# CITY OF ALBUQUERQUE

**Re: GAHP Casa Feliz  
523 Espanola Street SE  
Request for Permanent C. O. – Not Accepted  
Engineers Stamp Date 12/18/15 (L19D073I)  
Certification dated: 7/12/2017**

CD-210

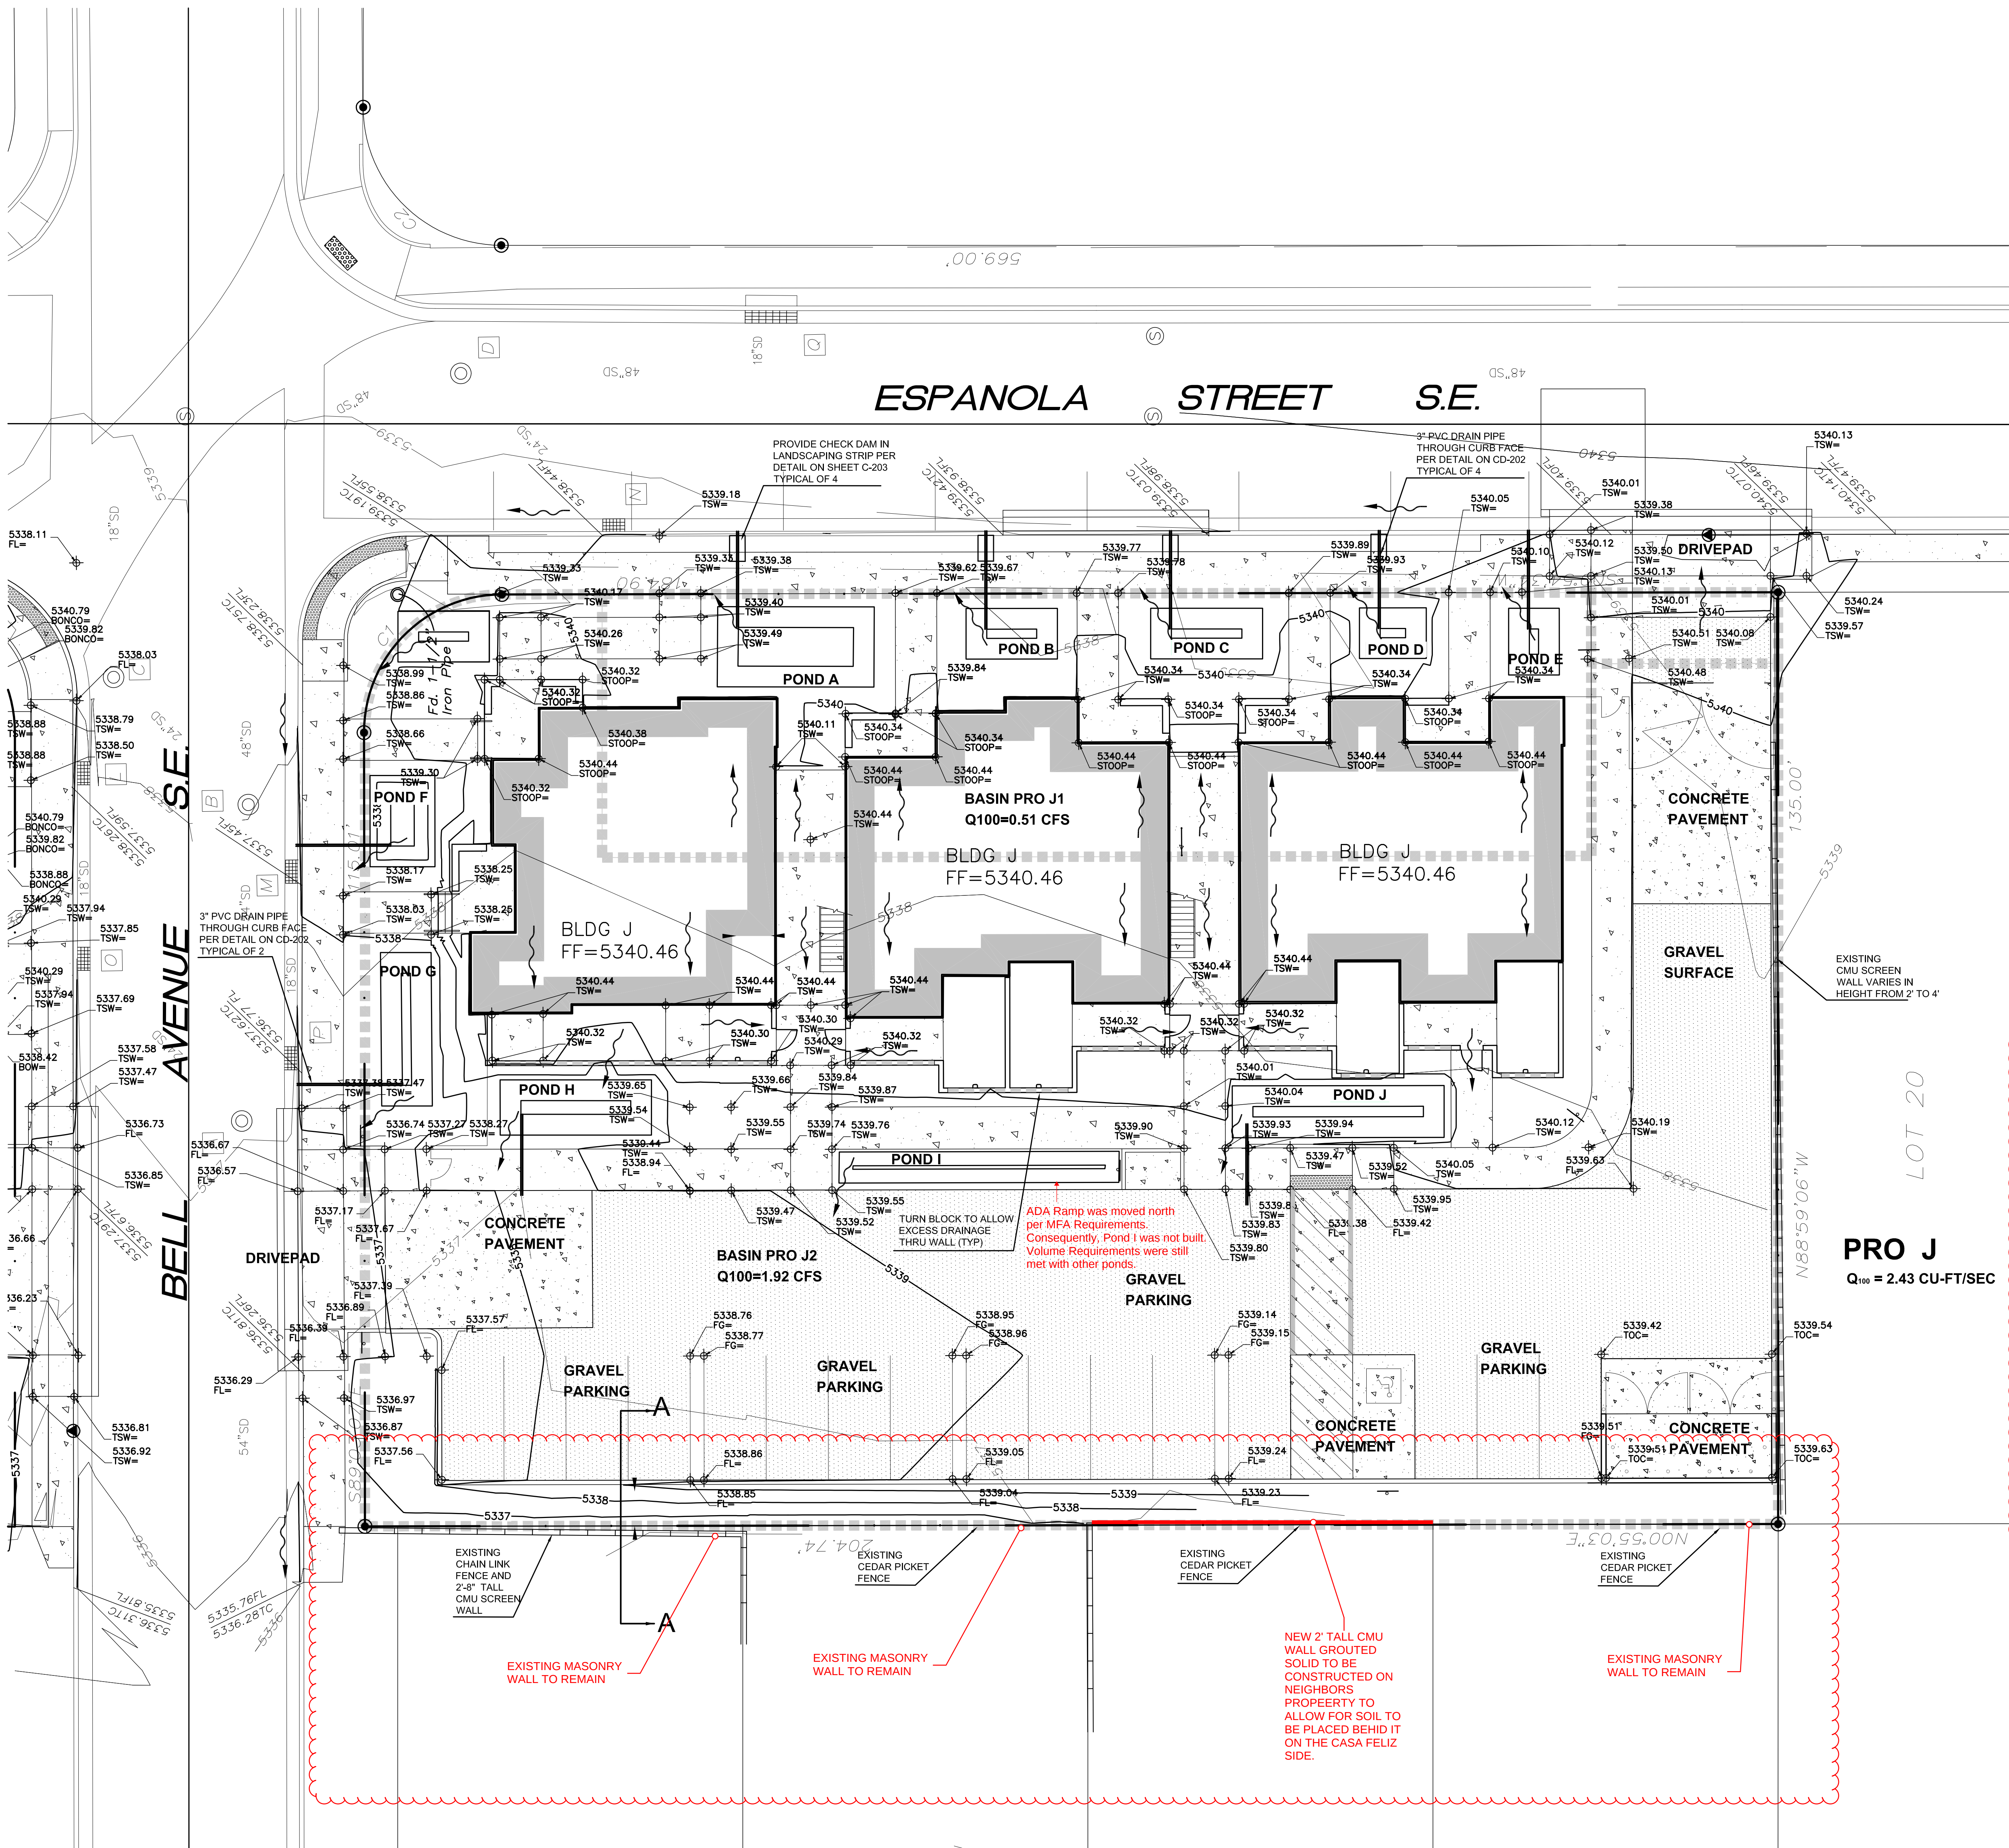
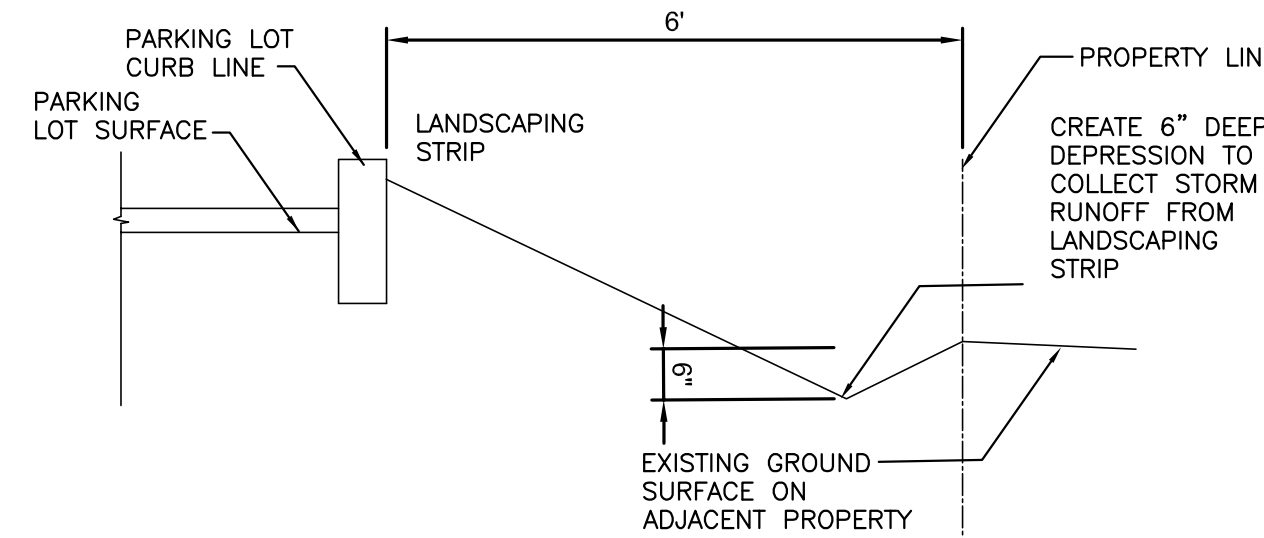
- Section AA has not been graded according to plan and cannot be graded according to plan without the addition of a retaining wall along west edge of the site. Two wooden fences retain about 2' of dirt (not allowed) and the 6" deep swale that is supposed to prevent cross lot drainage is missing.
- The original topo did not reflect all of the grade change from the parking lot to the adjacent property. A new survey is needed to measure the grade accurately, then the Grading Plan must be revised and resubmitted to hydrology to include a design of a wall along the west side of the site as necessary to prevent cross lot drainage.
- The revised plan should include a new engineer's stamp date.
- The revised Grading and Drainage Plan must include a detailed cross section from the parking lot to the existing grade on the adjacent lot.

CD-210

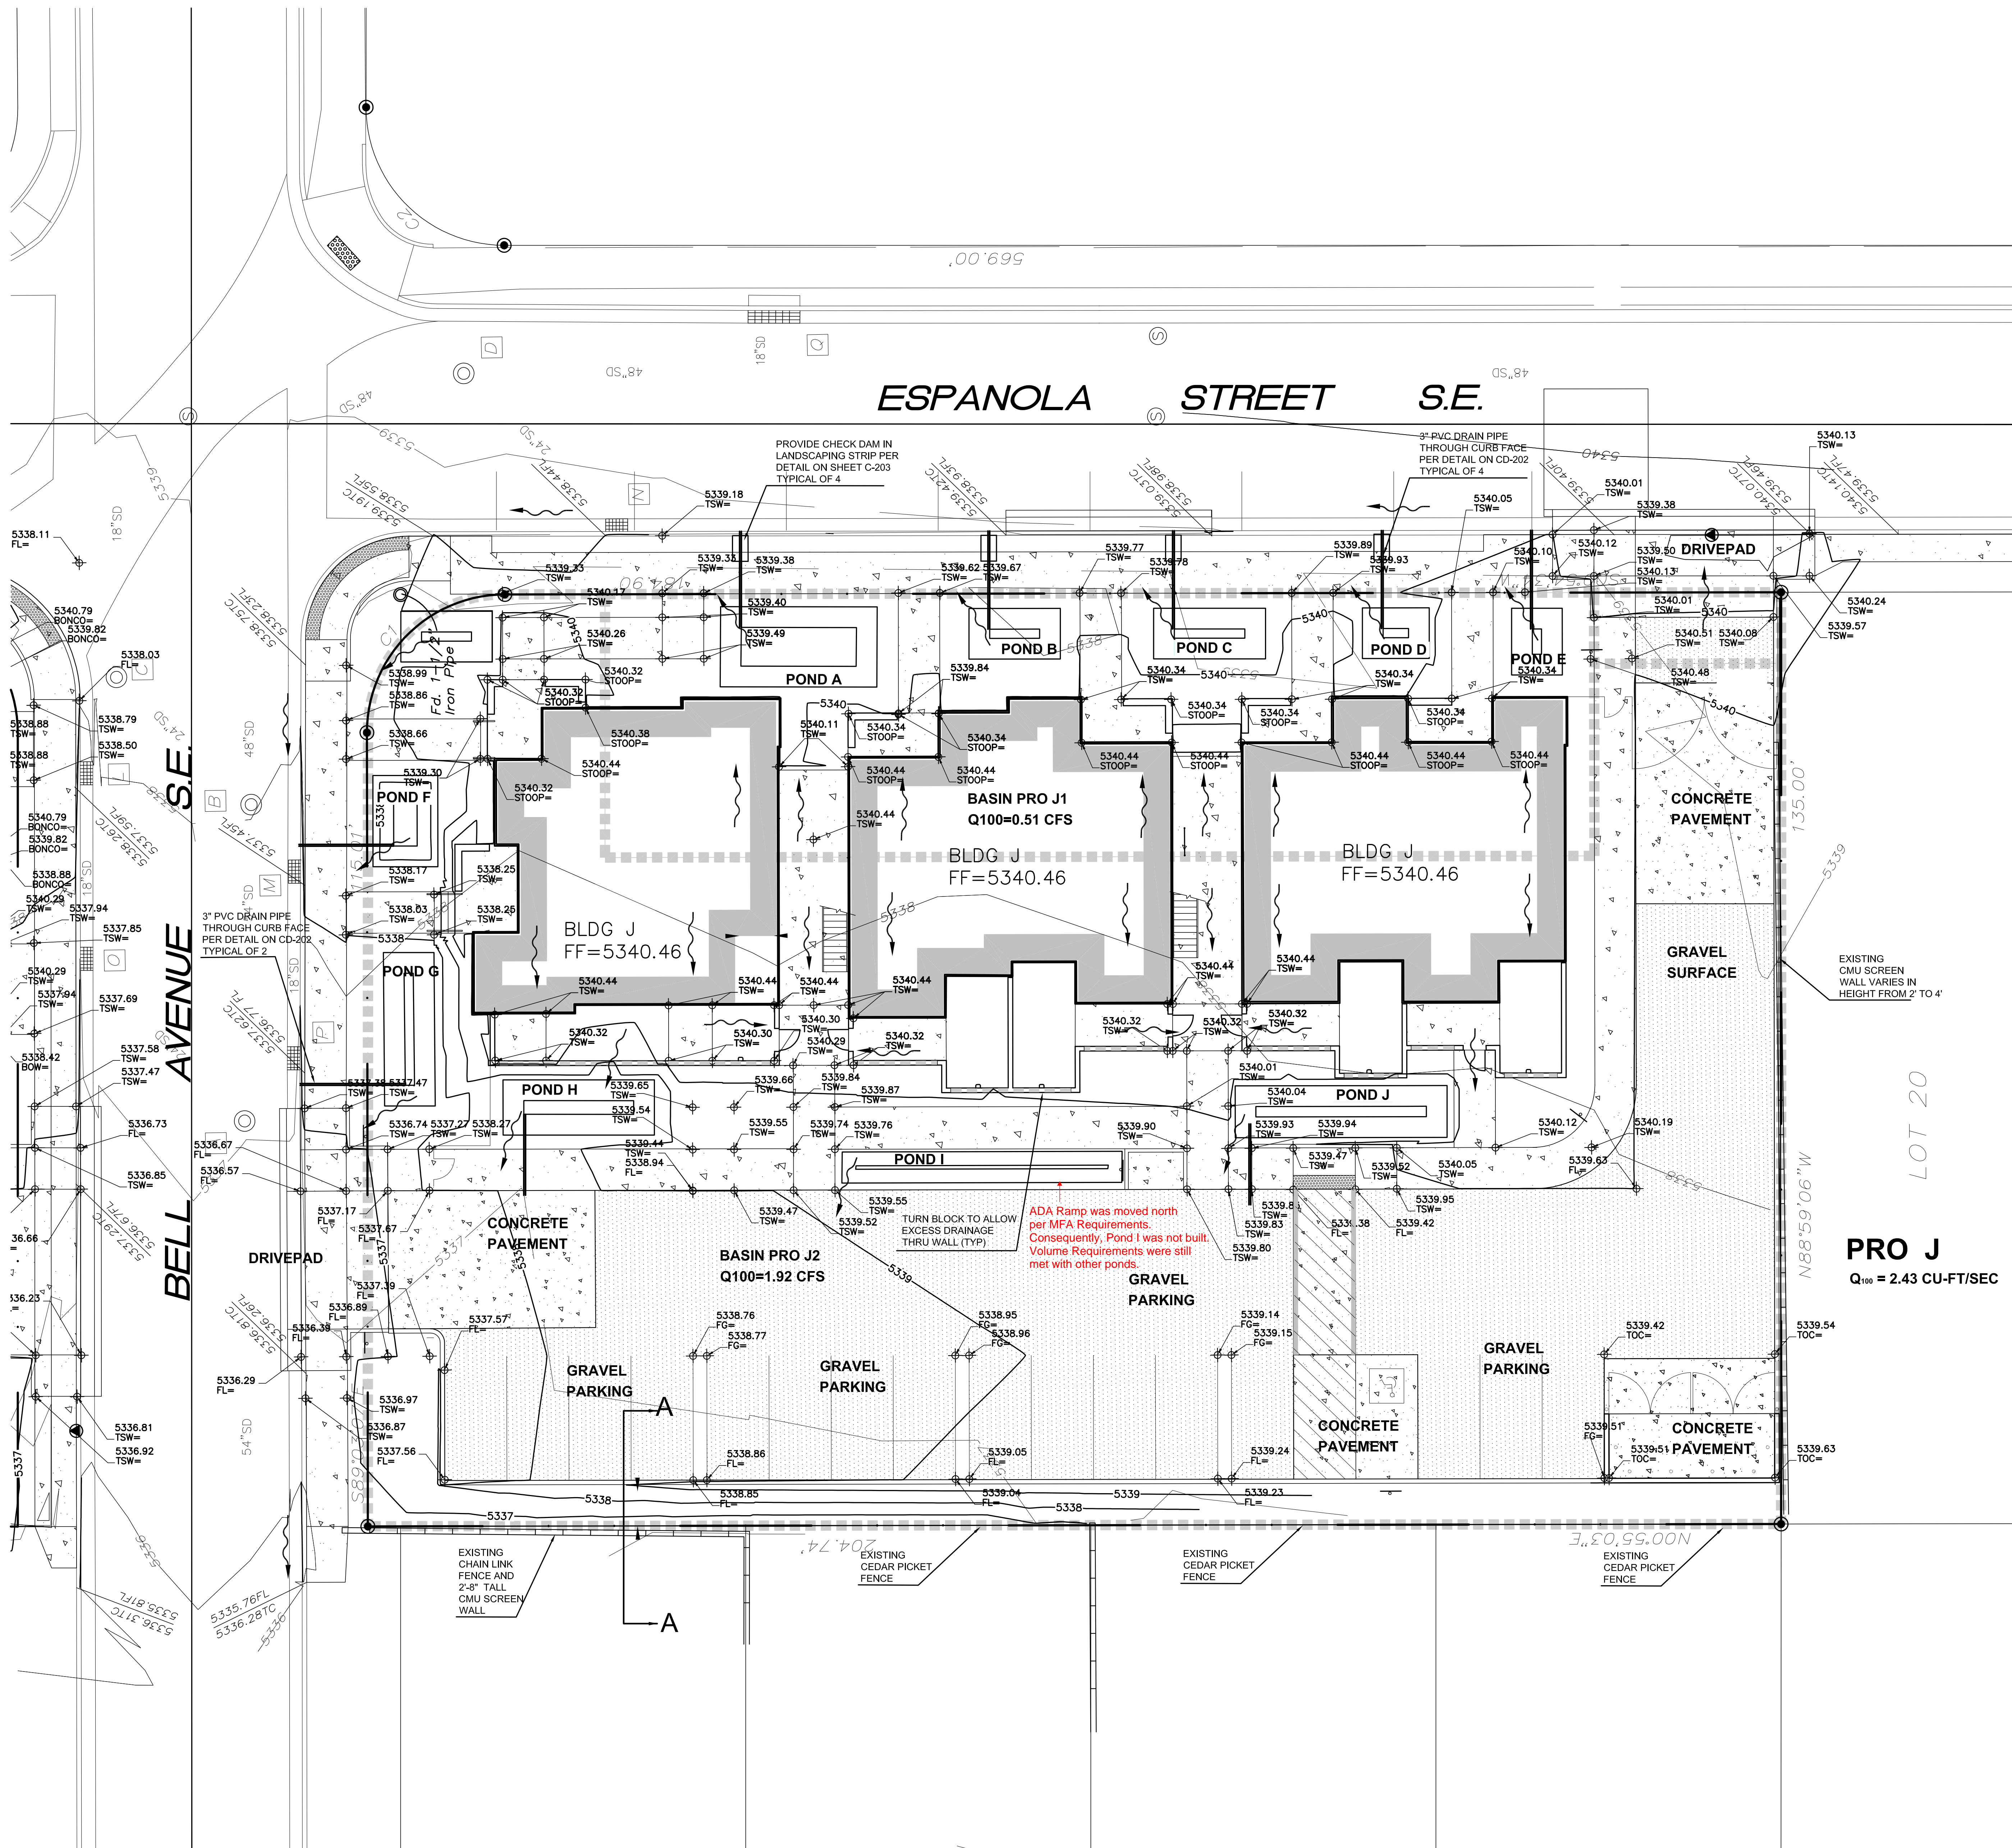
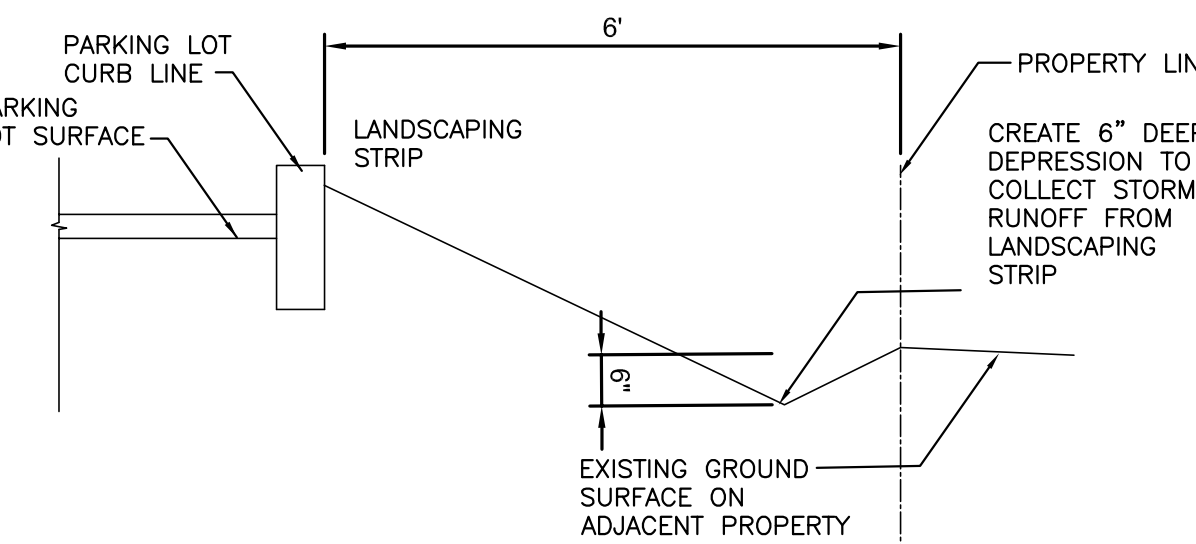
1. As-built survey information should be added to the plan to include spot elevations throughout the parking lot, the swale , and the finished floor elevations as well as the top of the new wall to be added on the west side of the property.
